TfNSW Reference: SYD21/00462/07

Departments Reference: SSD-17647189

**EXHIBITION OF EIS – ACCESS LOGISTICS PARK - 884-928 - MAMRE ROAD -
KEMPS CREEK**

Attachment A

Appendix B. Design Advice & Swept Paths

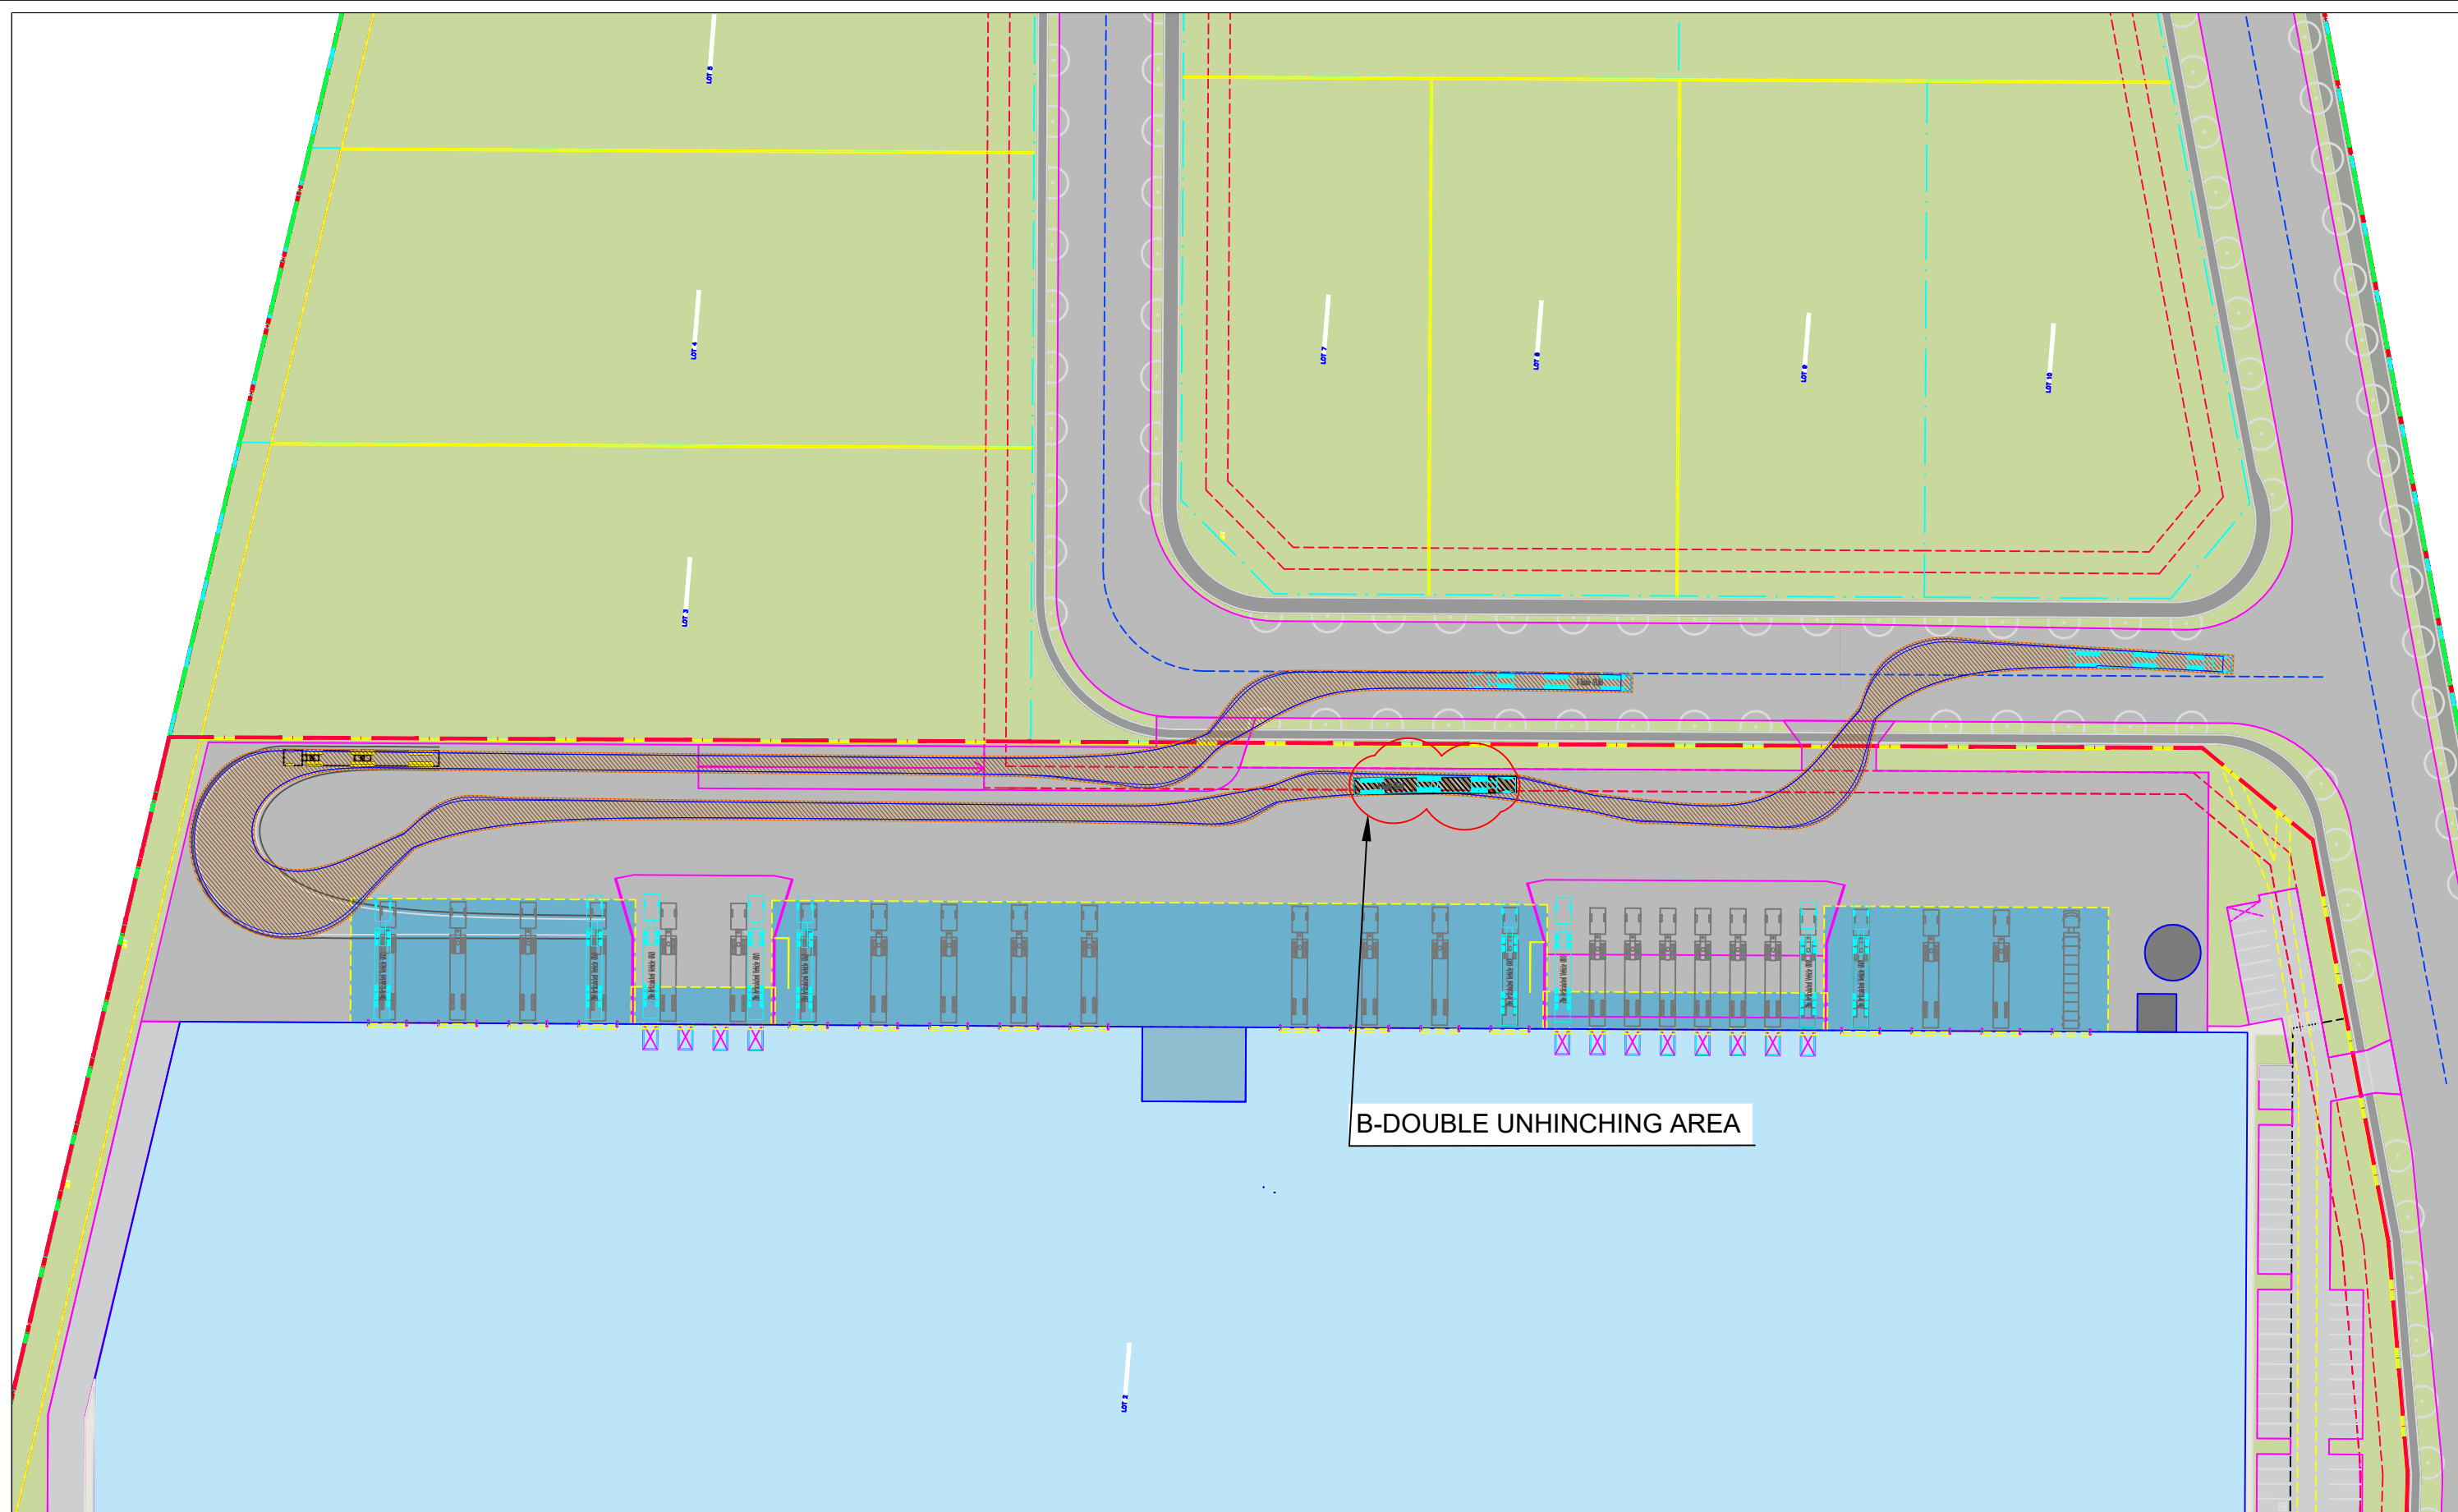
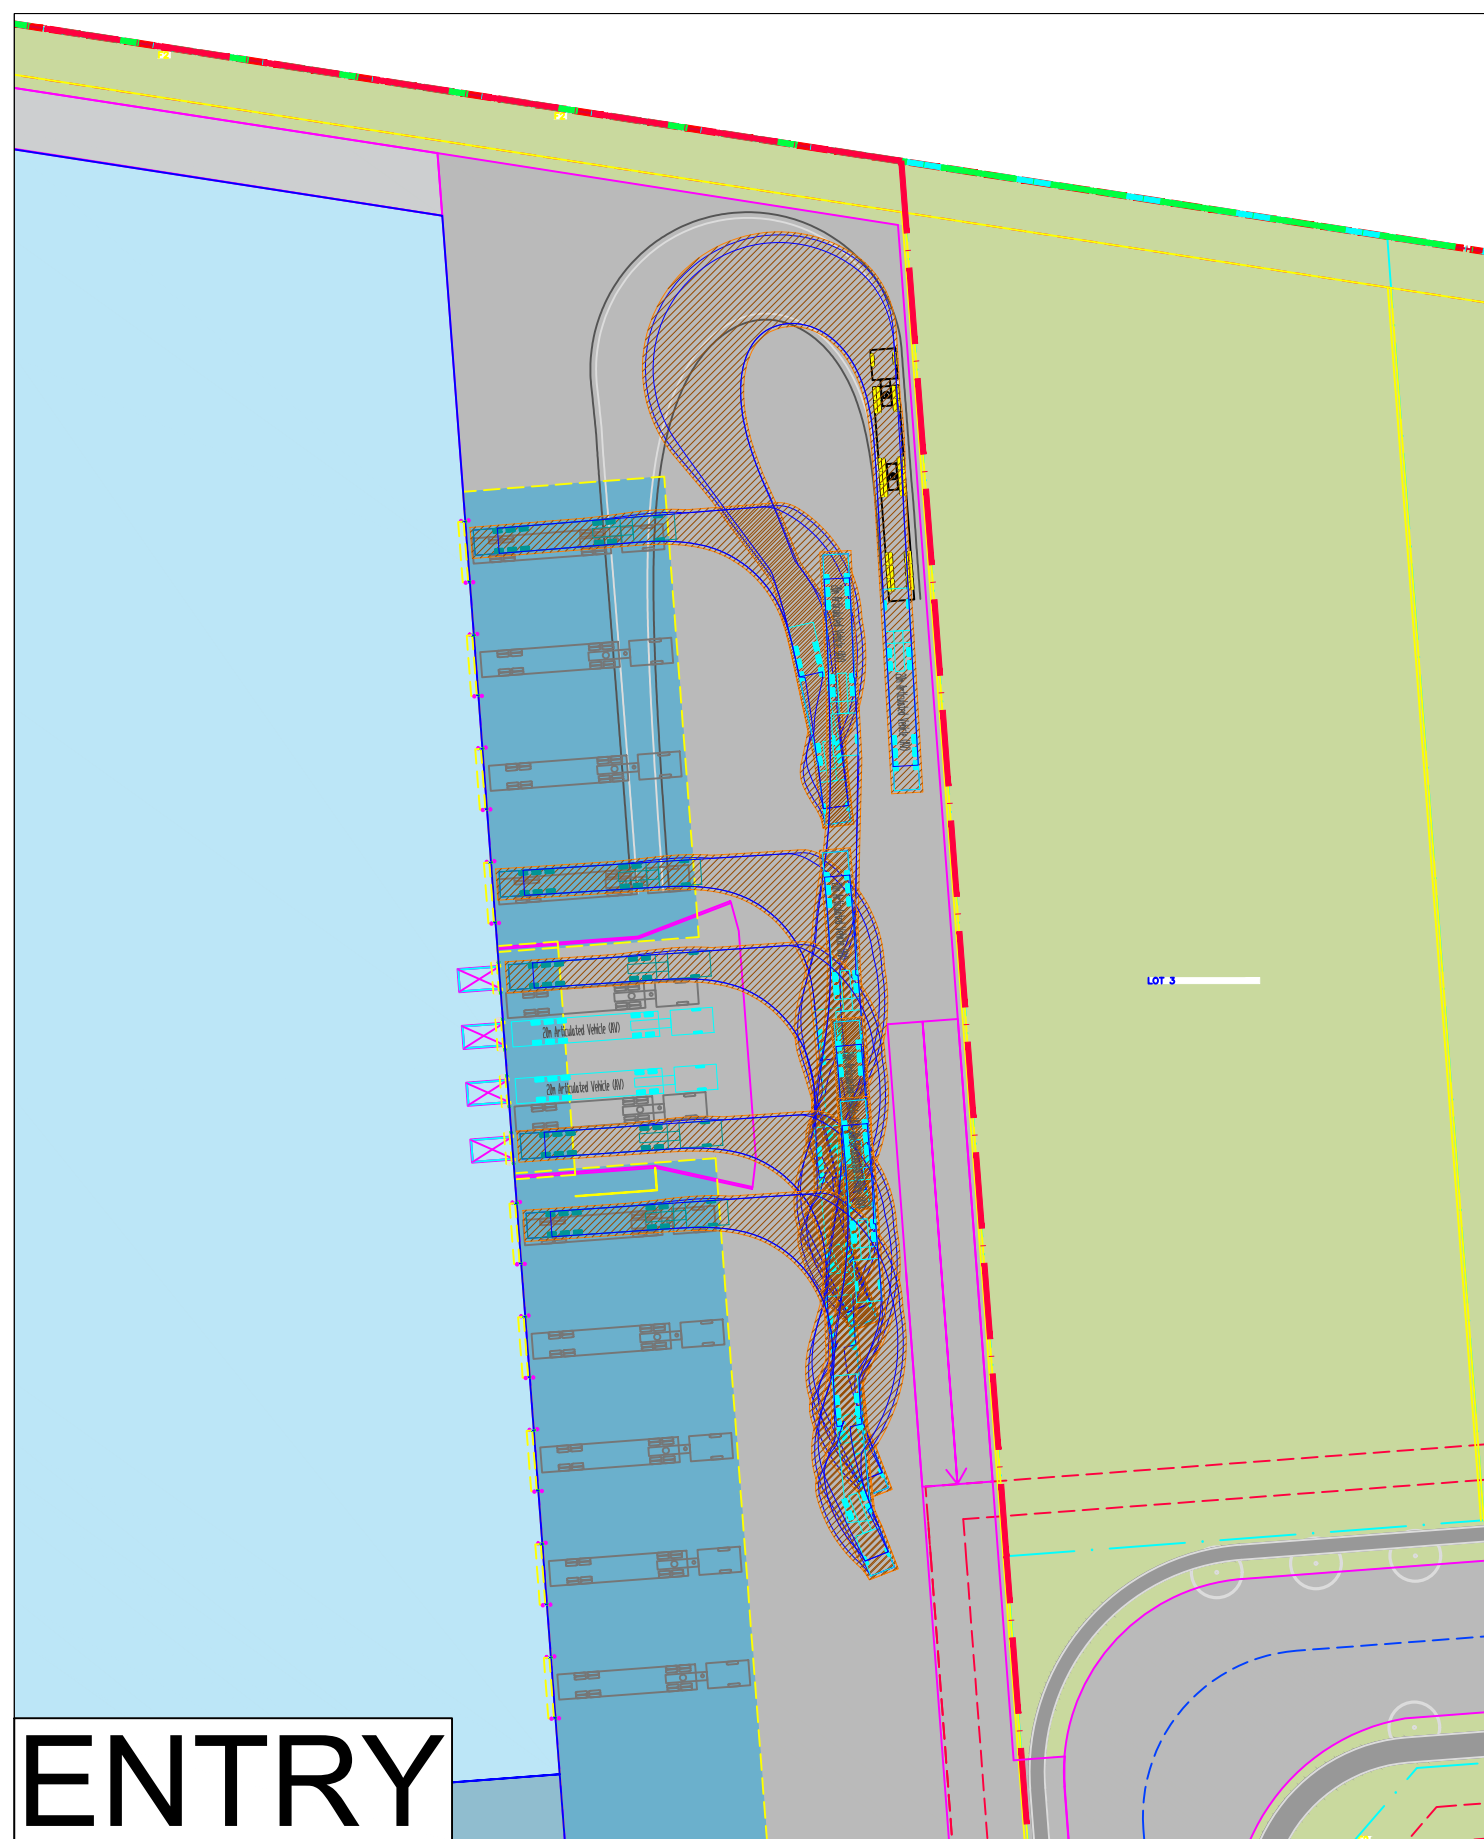
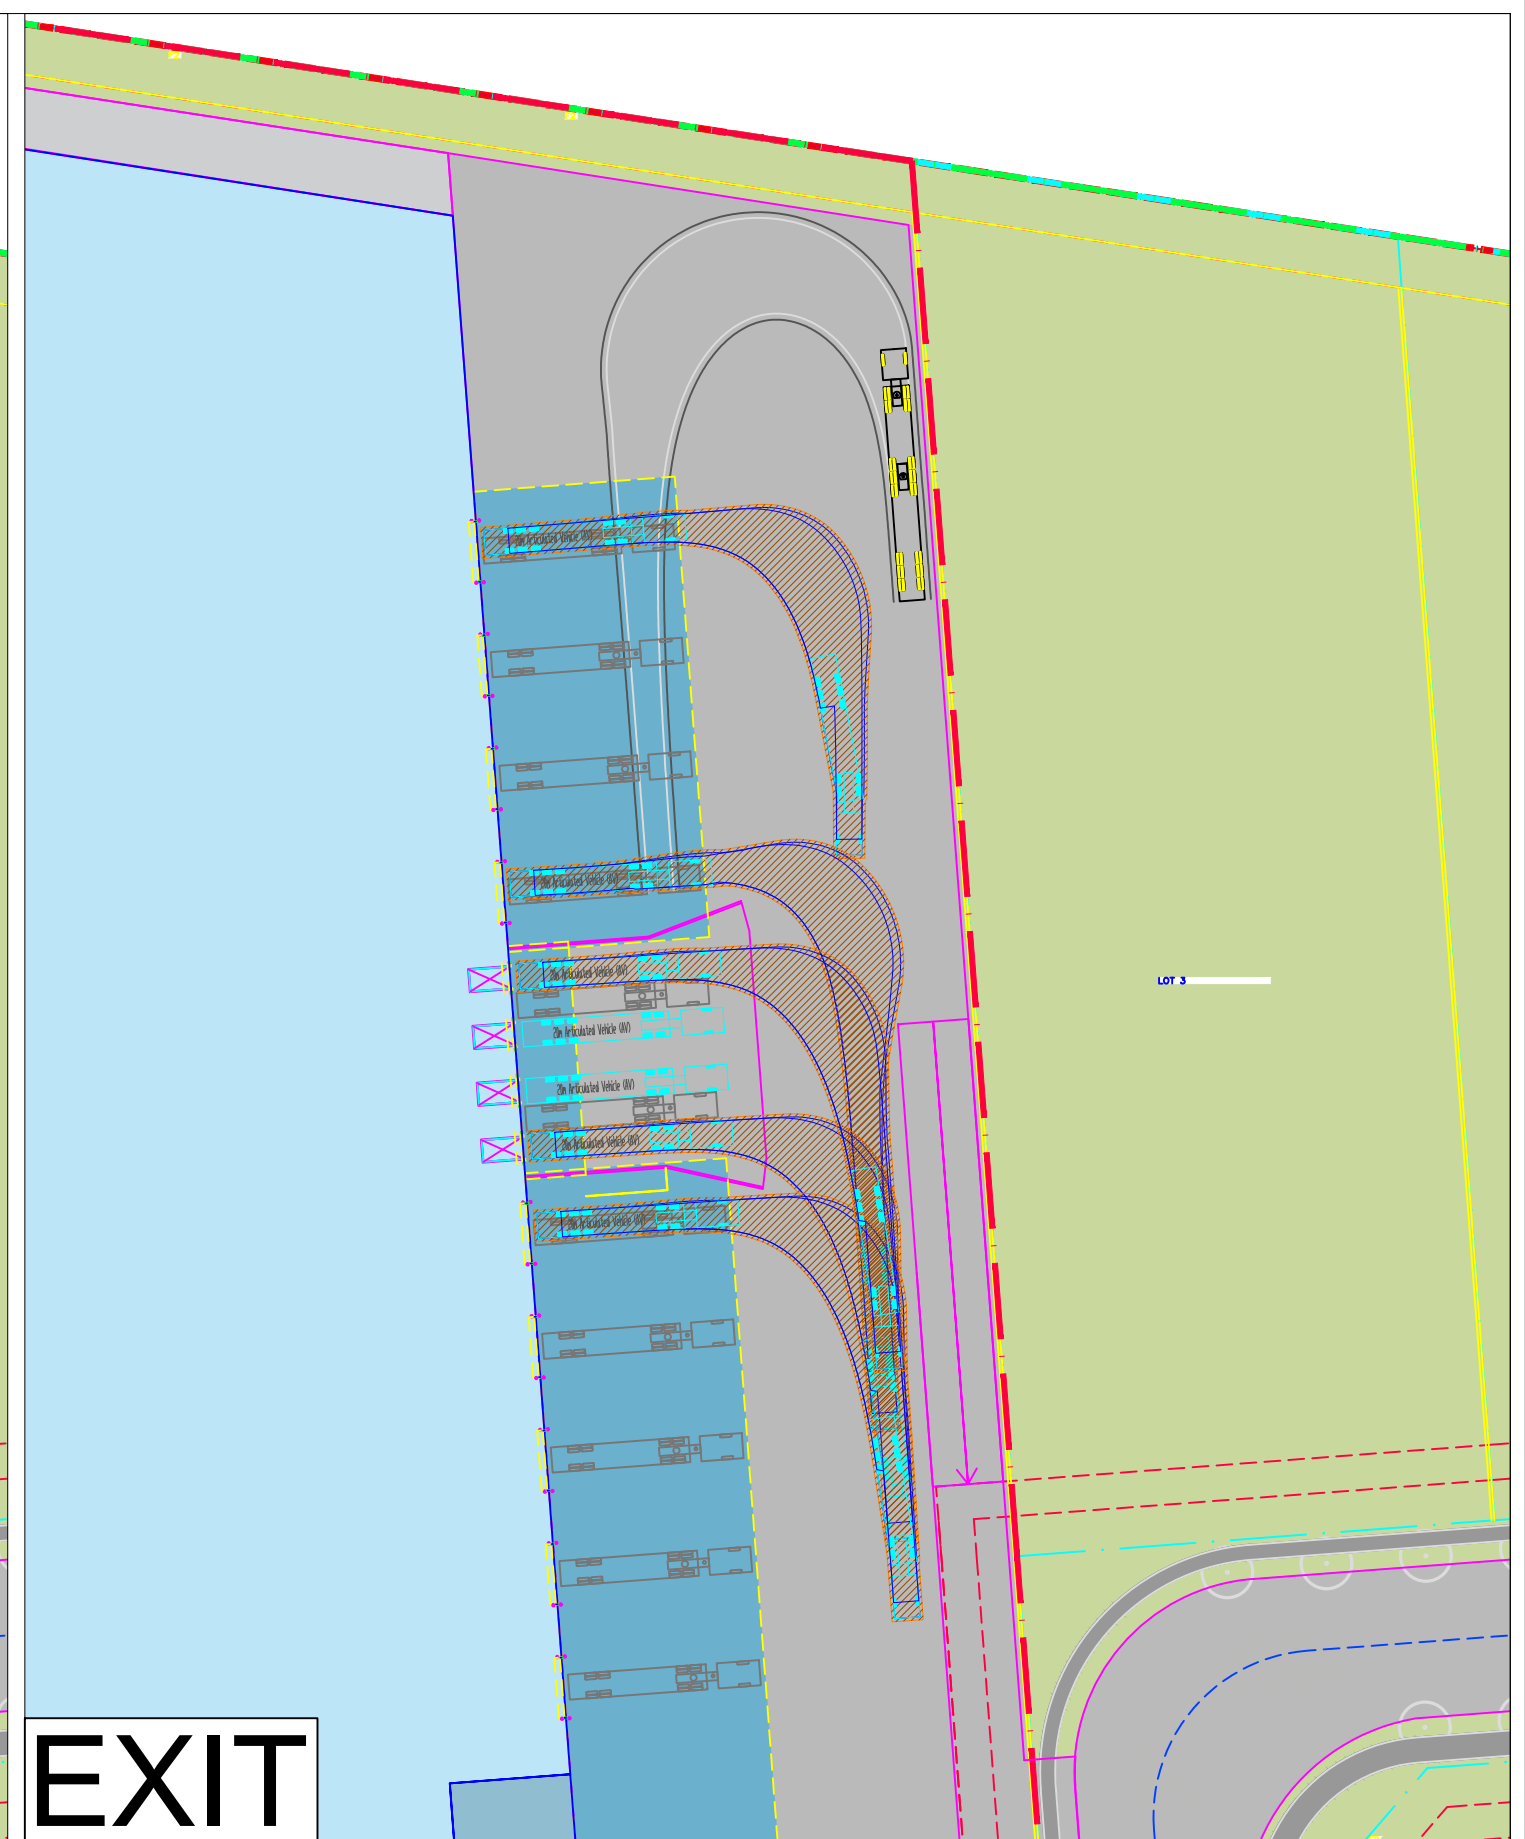
Appendix B. Design Advice & Swept Paths

- a. Swept Paths analysis is missing the test vehicle of 36m long B triple (PBS Level 3 Type A) as per the Mamre Rd Precinct Draft DCP.
- b. Figure 5 shows swept path diagrams for the proposed roundabout south-east corner of the site. No swept path appears to be provided for a vehicle travelling from west to east through the roundabout which would appear to be the tightest manoeuvre for a longer vehicle.

It is requested swept path diagrams be provided demonstrating the design vehicle is able to adequately manoeuvre through these intersections.
